Our Ref
PLAN-018394

Date
15/06/2017

Proposal: Demolition of existing garage & shed & erection of single storey rear & two storey side extensions.

Site: Pound Cottage, The Street, Walberton, BN18 0QA.
WA/32/17/HH

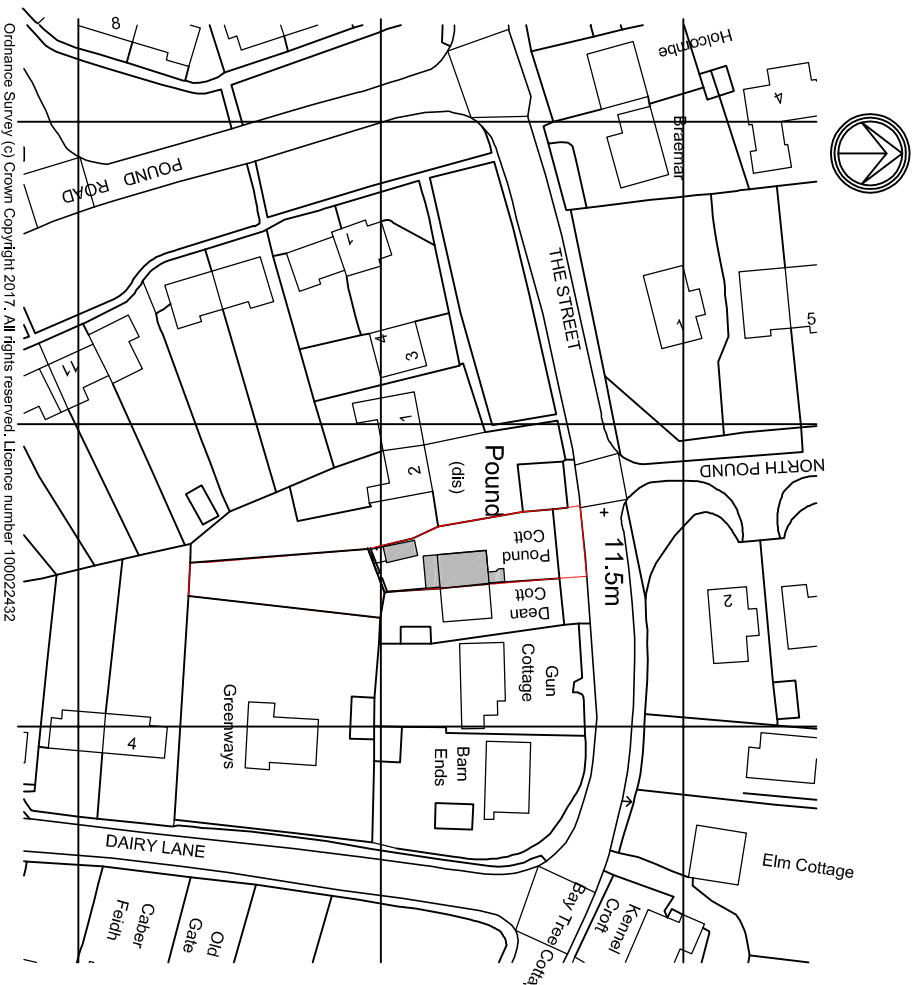
The proposed plans indicate that the proposed development lies over an existing foul drain/sewer not shown on public records however deemed to be transferred into public ownership due to changes in legislation that came in to force on 1st October 2011. The exact position and ownership of the foul sewer must be determined on site by the applicant before the layout of the proposed development is finalised.

Building over a "public sewer" is not normally permitted by Southern Water. However, under certain circumstances building over a minor sewer may be allowed. The conditions associated with the buildover/close to a sewer are contained in Southern Water guidance notes which are available at: www.southernwater.co.uk. A formal application to build close to the sewer will required to be submitted by the applicant . The developer should assure access to maintain the drain is not impeded and that adequate protection measures are put in place.

It might be possible to divert the foul sewer, so long as this would result in no unacceptable loss of hydraulic capacity, and the work was carried out at the developer's expense to the satisfaction of Southern Water under the relevant statutory provisions.

In order to protect drainage apparatus, Southern Water requests that if consent is granted, a condition is attached to the planning permission. For example: "The developer must agree with Southern Water, prior to commencement of the development, the measures to be undertaken to protect the public sewer."
